A38 Derby Junctions
TR010022

8.107 Written Summary of Oral
Submissions to ISH7 09 June 2020

**Written Summary of Oral Submissions to ISH7
09 June 2020**

FIGURE 2.12D ENVIRONMENTAL MASTERPLAN (MARKEATON JUNCTION)

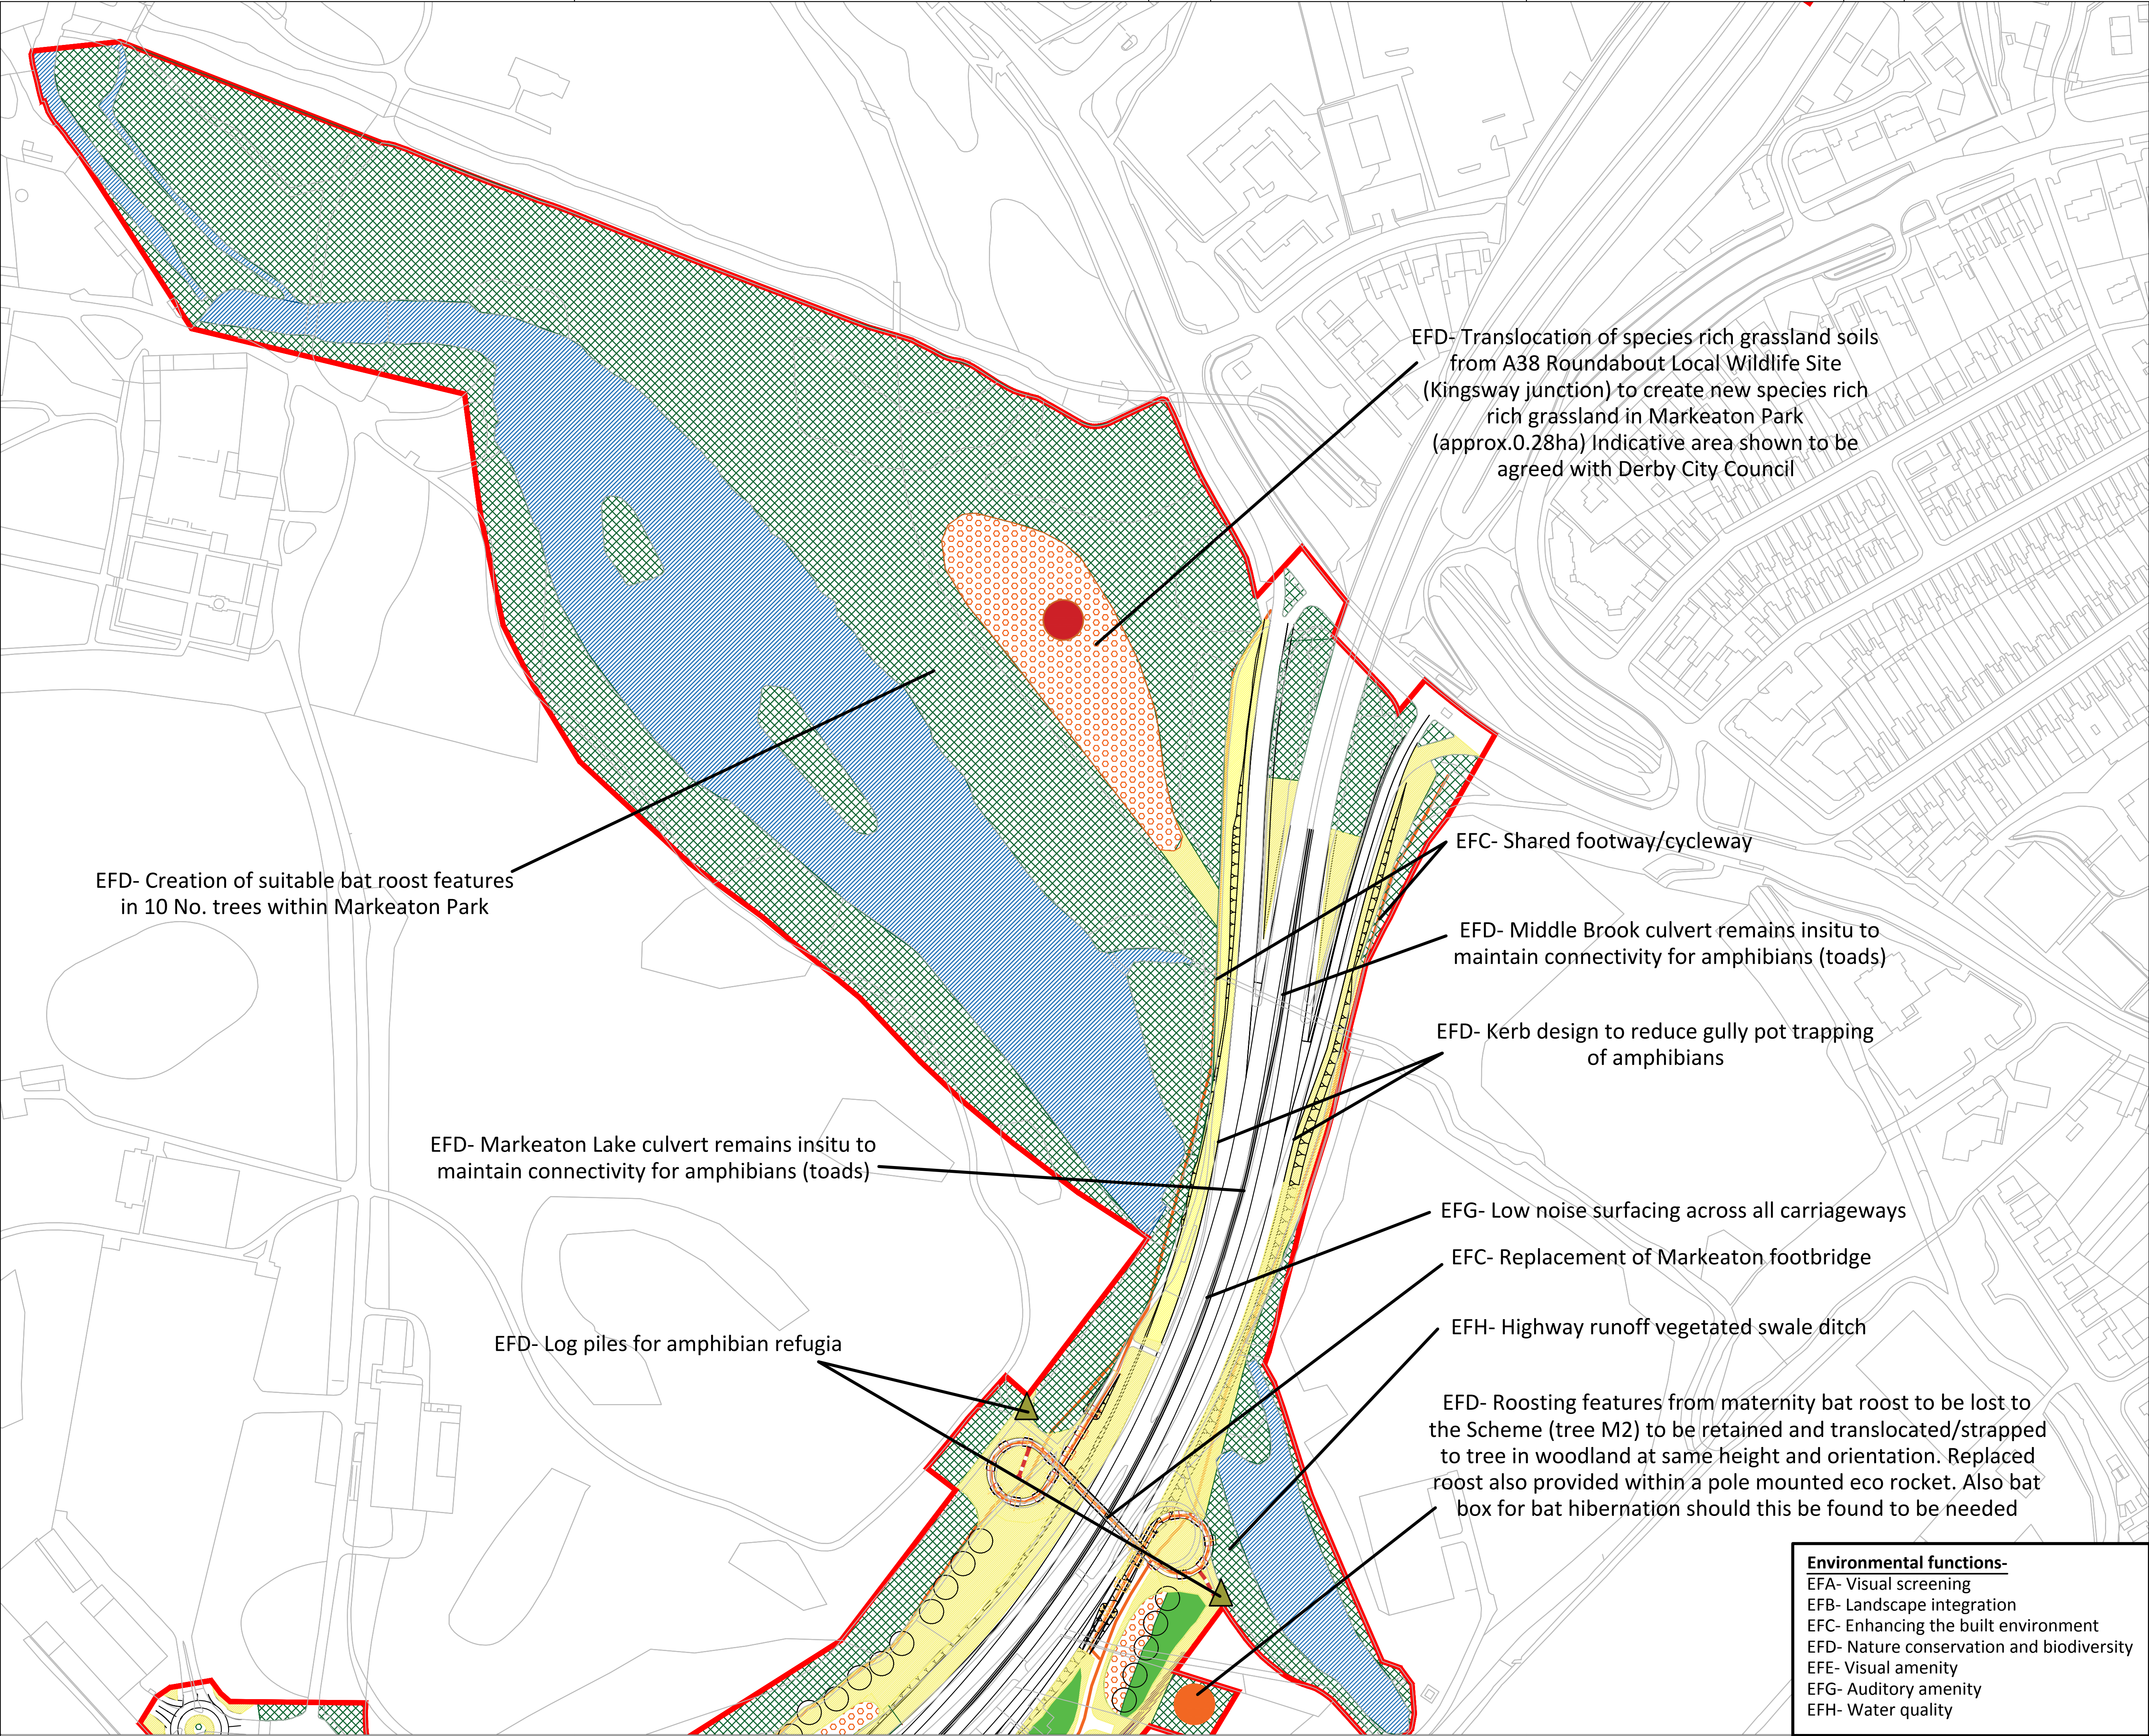
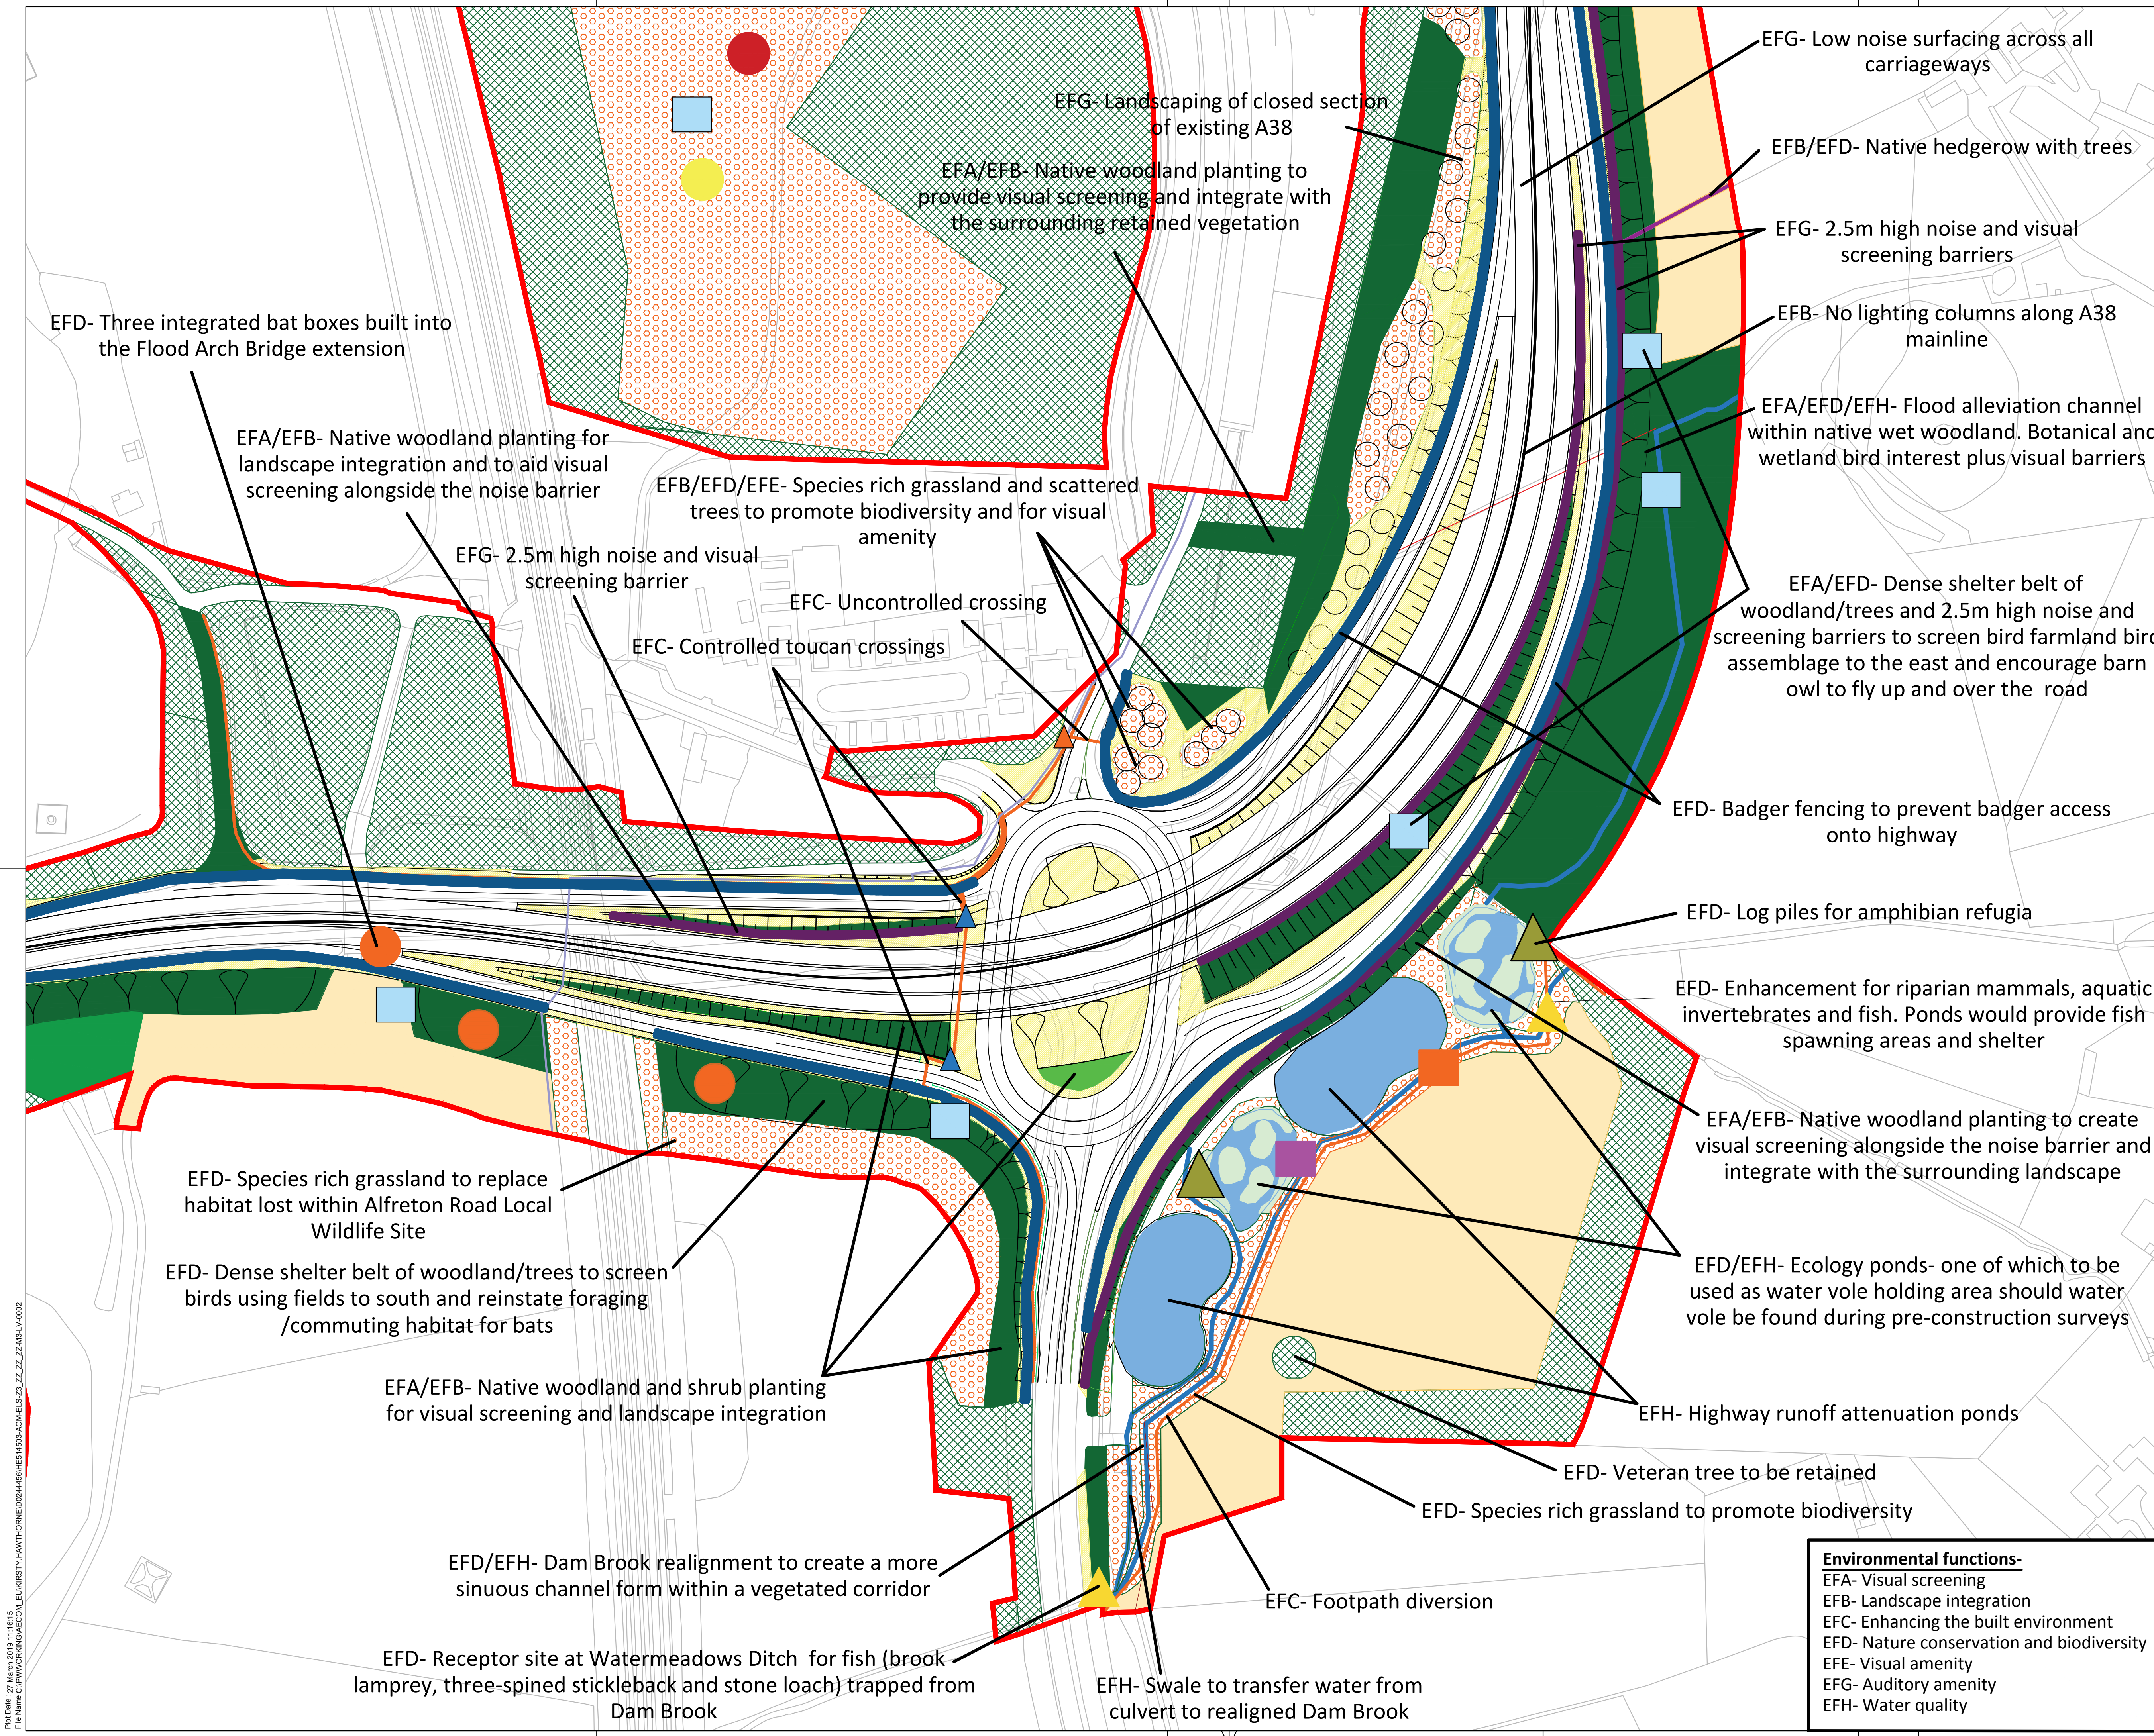
<p><u>Other matters</u></p> <p>e) Any other matters on the topic?</p>	<p>No other matters raised.</p>
<p>Landscape and visual impact</p>	
<p><u>The effect of the proposed development on veteran tree T358</u></p> <p>The Applicant's submission [REP7-007 paragraph 7.1] sets out its approach to the retention of the veteran tree. This includes the possibility of retaining the tree with a reduced canopy. The OEMP [REP12-002, page 25, item PW-LAN] has also been amended.</p> <p>a) Are Derby City Council content with the OEMP provisions?</p>	<p>Derby City Council confirmed that they are now more reassured with regard to Highways England's proposals to retain the veteran tree. Derby City Council explained that they are comforted by the knowledge that Highways England's compliance with the OEMP is a DCO requirement. Derby City Council added that they now have more comfort in going forward and working with Highways England on the design and at various stages of impact testing on the tree.</p>

<p>b) Do the Friends of Markeaton Park have any comments?</p>	<p>Anne Morgan asked for further explanation as to why the red line boundary on the east side of the park could not be moved so that the tree falls outside of the Scheme. Anne Morgan questioned whether the position of the bridge could be moved. Anne Morgan later explained that they had been confused between the east and west sides of the site.</p> <p>Highways England explained that the positioning of the bridge was originally sited further to the south of the current position. However, following a non-statutory consultation in 2015 and discussions with local residents and users of the park, it was decided that the bridge should be situated in the current position. The reason for this was to maintain existing trees to the greatest possible extent on the western outer edges of the park. If the bridge were to be</p>

<p>relocated, it would have further significant impact on trees in that area. The reason for the extension of the bridge to the east is associated with the carriageway alignment.</p> <p>Highways England referred to the Highways England document Veteran Tree Loss TS58 [REP7-008]. Highways England explained that the map clearly shows the outline of the root protection area (RPA). Highways England explained that the RPA does extend under the proposed carriageway and that there will be a degree of invasive work done in that area. However, Highways England has agreed that should it become apparent during the detailed design stage that the tree can be retained, but that impacts on the tree's RPA remain, options to reduce the tree's canopy will be investigated. Highways England added that for the purposes of the Environmental Impact Assessment it was assumed that the tree would be lost, despite the position in the OEMP. Highways England explained that the OEMP includes measures to ensure that Highways England protects the tree to the extent possible. Highways England also explained that, in terms of the road and the bridge, Highways England has considered everything that was raised in the consultation and have taken appropriate action in response.</p> <p>The ExA questioned whether the measures in the OEMP, as it stands now, would allow for the eastern end of the bridge to move northwards so as to move closer to the magenta line on the map [REP7-008], and therefore slightly further away from the tree canopy. Highways England explained that they have not looked into this point in detail because movement further east would impact the Mill Pond, which is situated very close to that area. However, the exact position of the footbridge will be reviewed during the detailed design stage.</p>
